**PLANNING AND COMMUNITY DEVELOPMENT**  
CRAIG DOSSEY, EXECUTIVE DIRECTOR

2/20/18

Subject: Academy Gateway 7-11 Site Development Plan Review 2

DEVELOPMENT PLAN  
**7-ELEVEN**  
 SITE PLAN

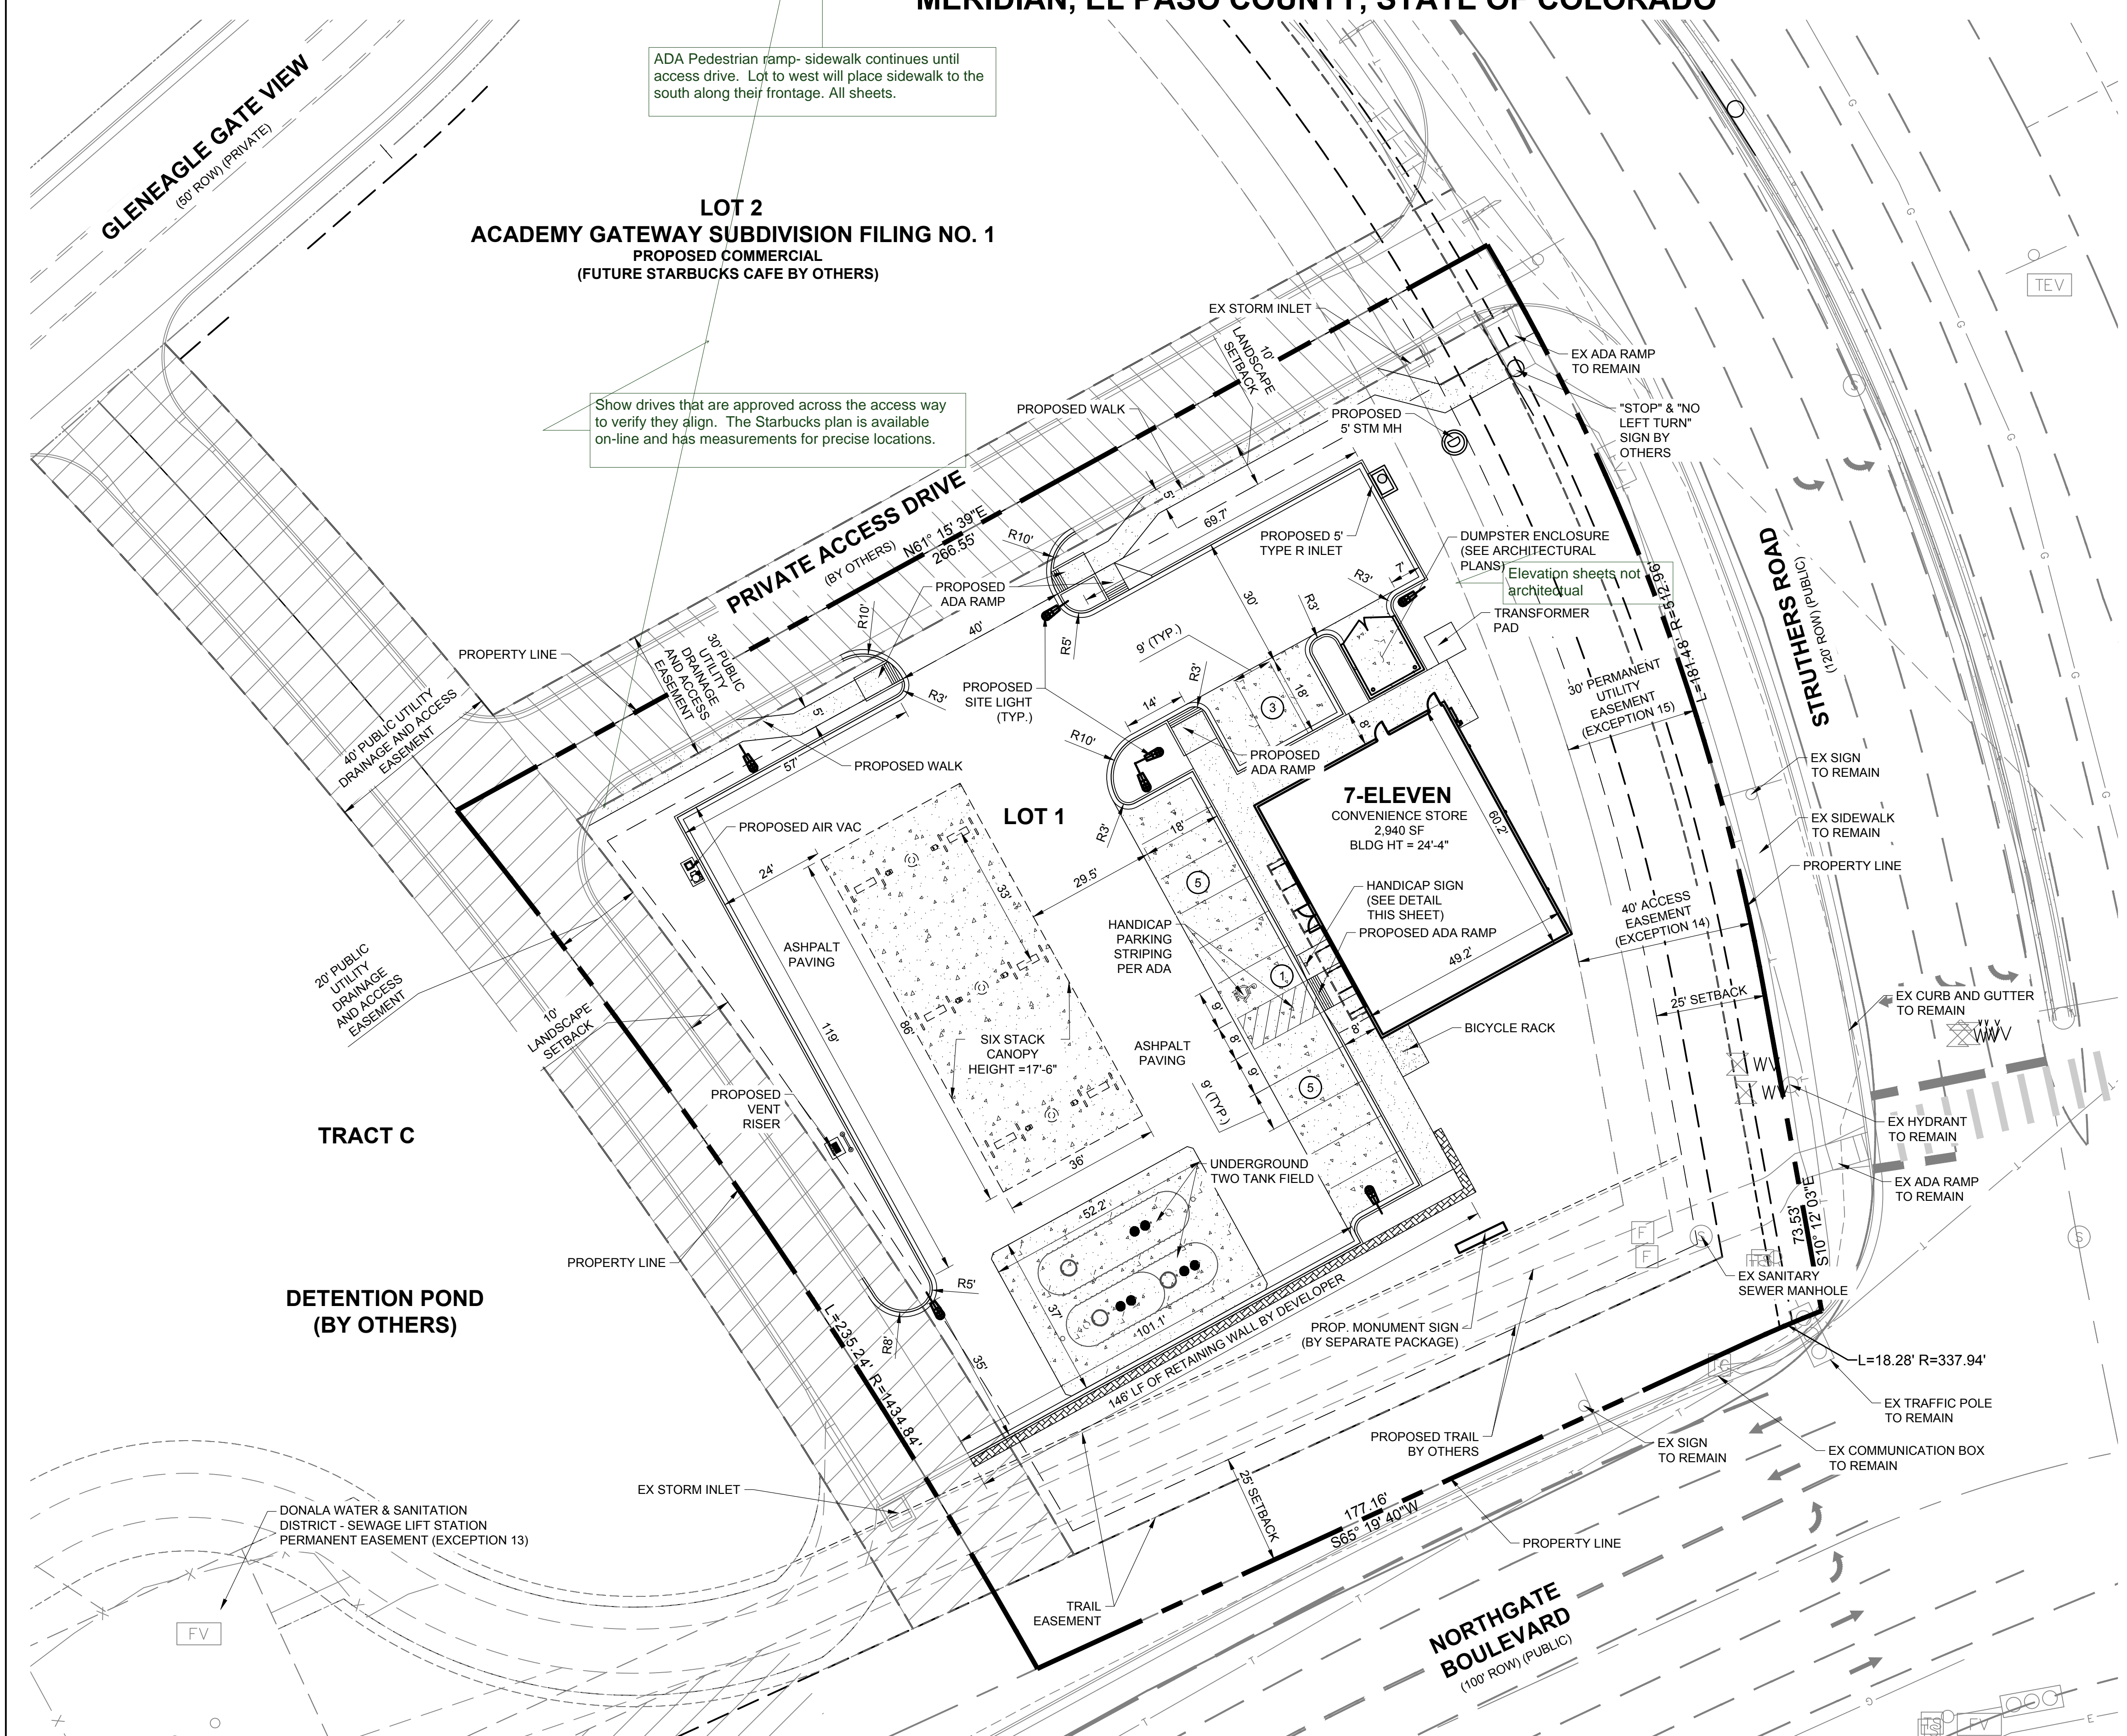
1. See electronic redlines. **See updated redlines.**  
**Future ped ramp by others label added to site plan. Trail width and legibility revised.**
2. **Resolved OK**

DEVELOPMENT PLAN	7-ELEVEN	GRADING PLAN
LOT 1 ACADEMY GATEWAY SUBDIVISION FILING NO. 1		
PROJECT NO:	7E1024.01	
DESIGNED BY:	SPM	
DRAWN BY:	LER	
DATE:	12/04/17	
<b>C2.0</b>		
SHEET 3 OF 16

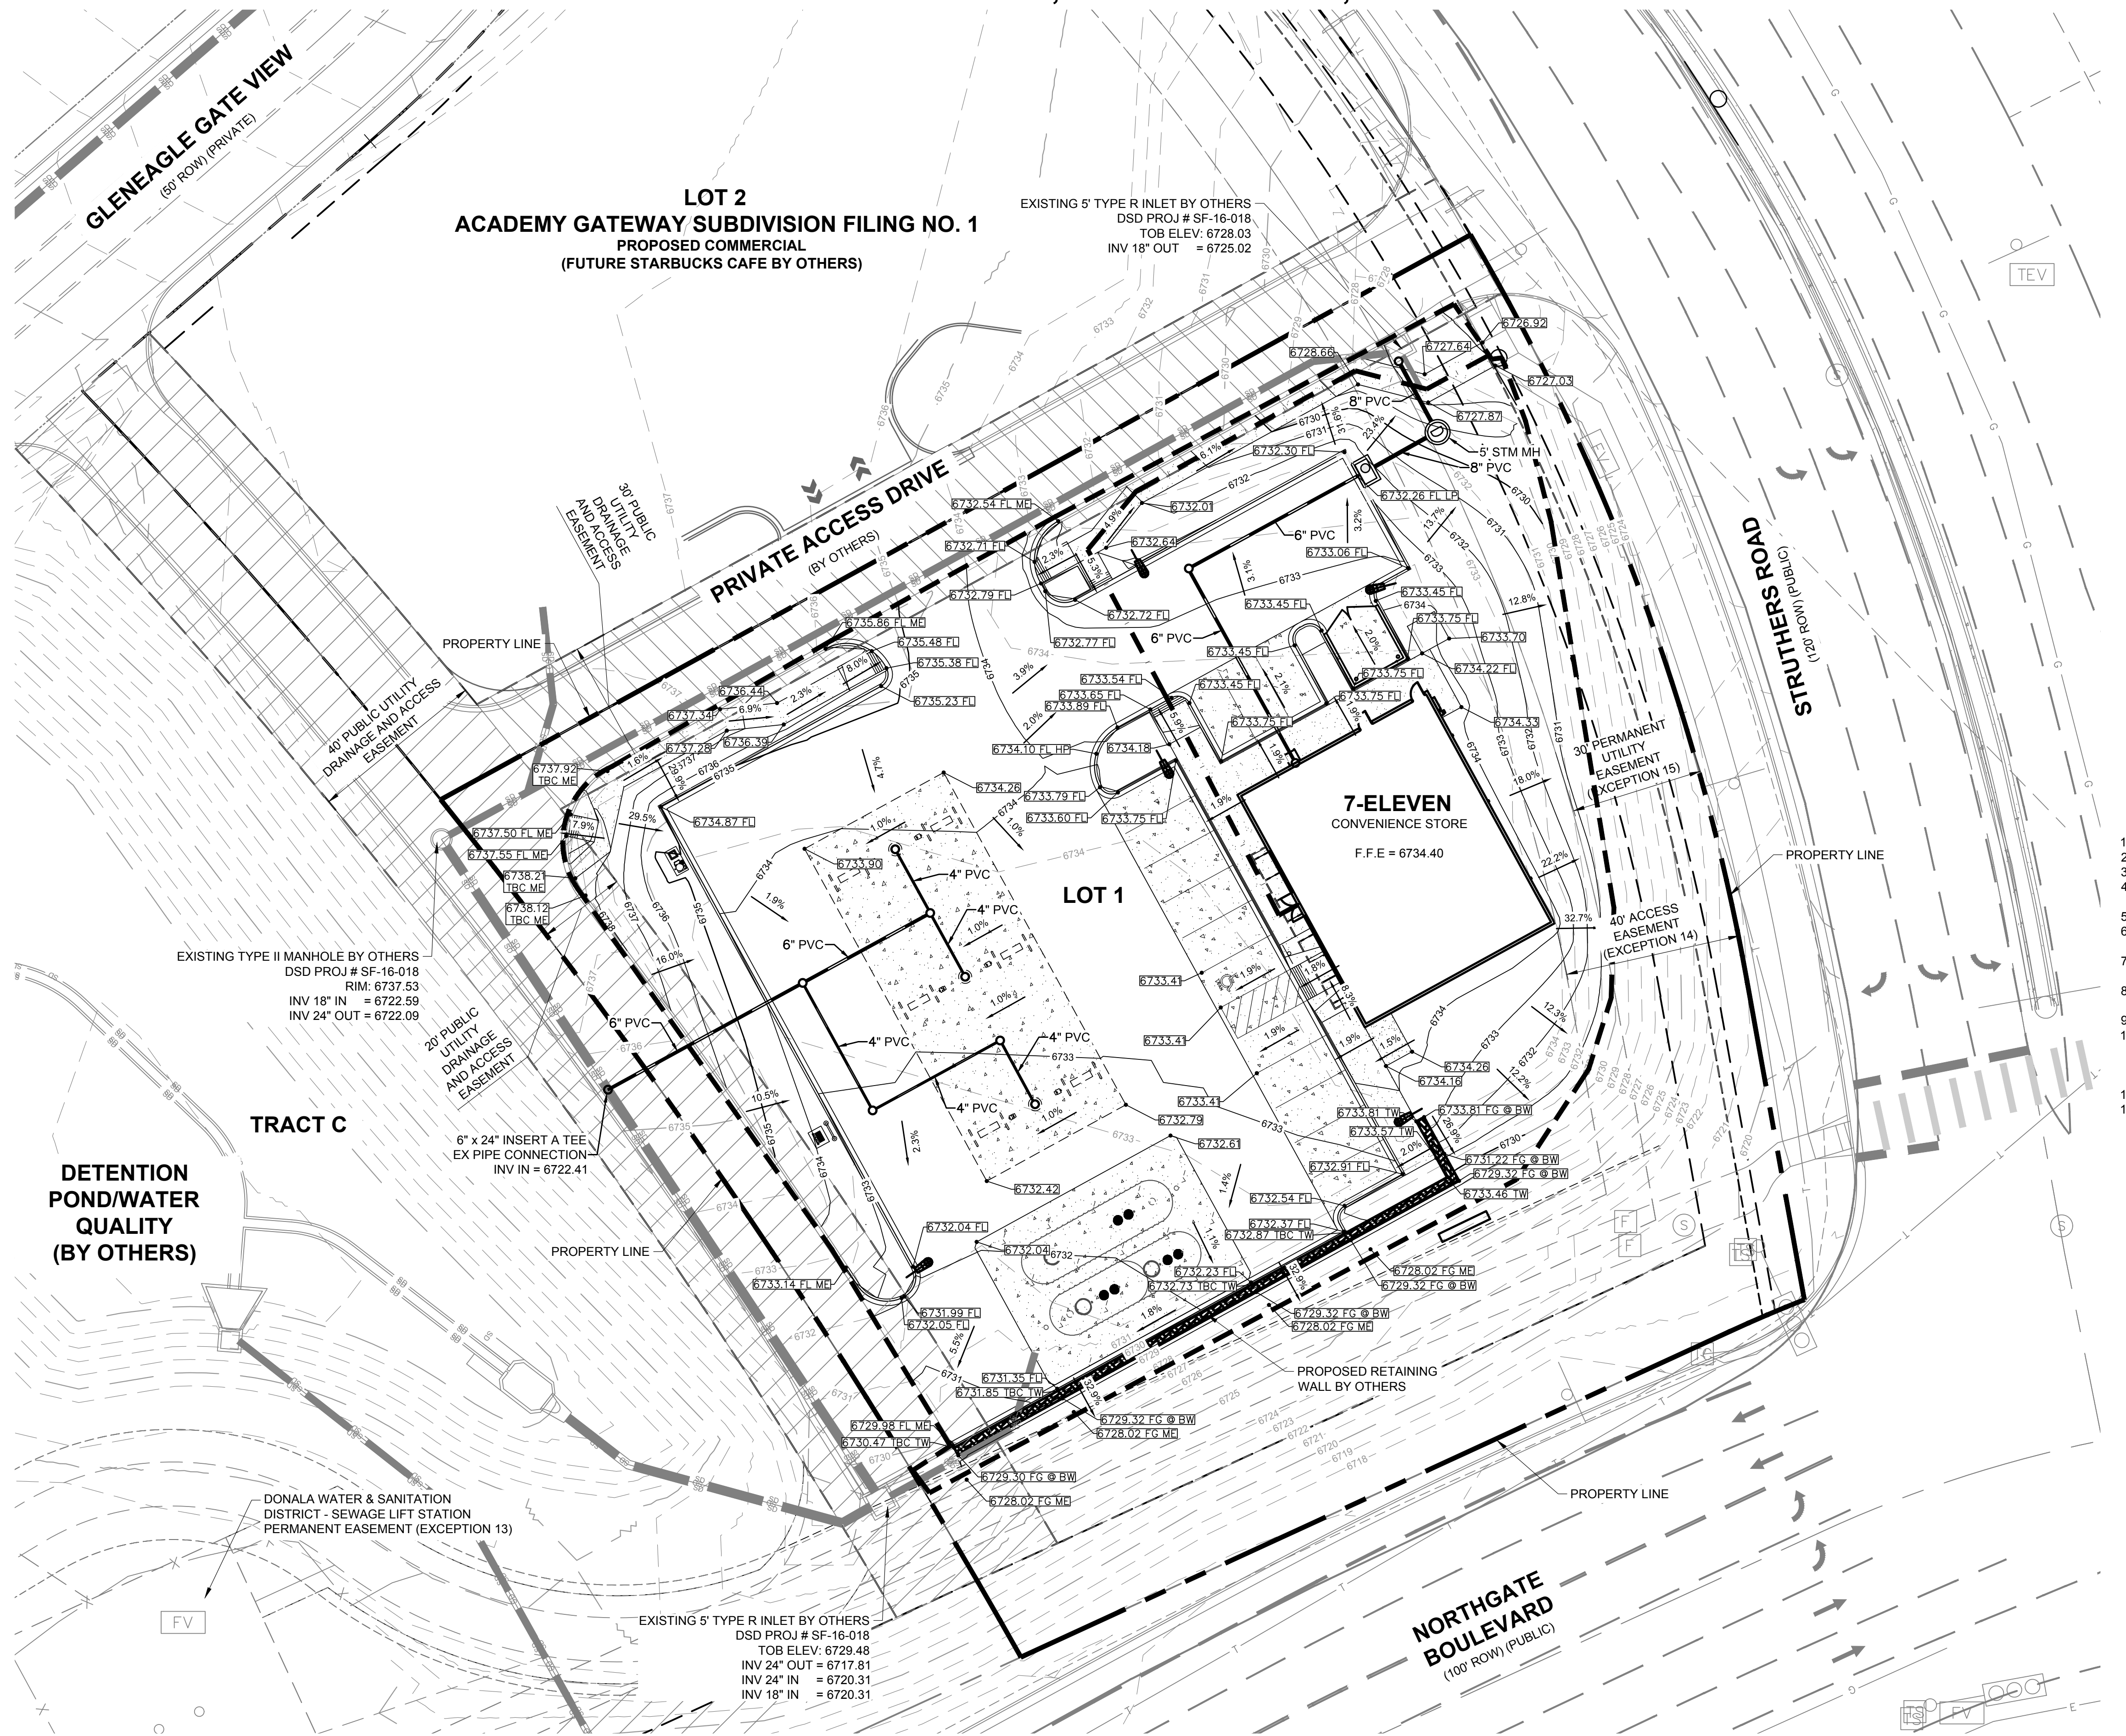
1. **Resolved OK**
2. See redlines on the GEC Plan document. **See updated redline.**  
**Only comment pertains to revised ped. Ramp. Per most recent discussion with Elizabeth Nijkamp, the current configuration and radial ramp is acceptable for this private drive. Plans to remain as designed for this comment.**
3. **Resolved OK**
4. Please verify in the letter of intent that the project will be subject to the State stormwater permit and SWMP, if that is the case. If not, a site SWMP will need to be submitted.  
**Partially resolved; specify in the SWMP that stabilized vegetation levels will be 70% of the level pre-overlot grading. Provide that value from the Academy Gateway Filing 1 SWMP.**  
**Comment addressed in report.**
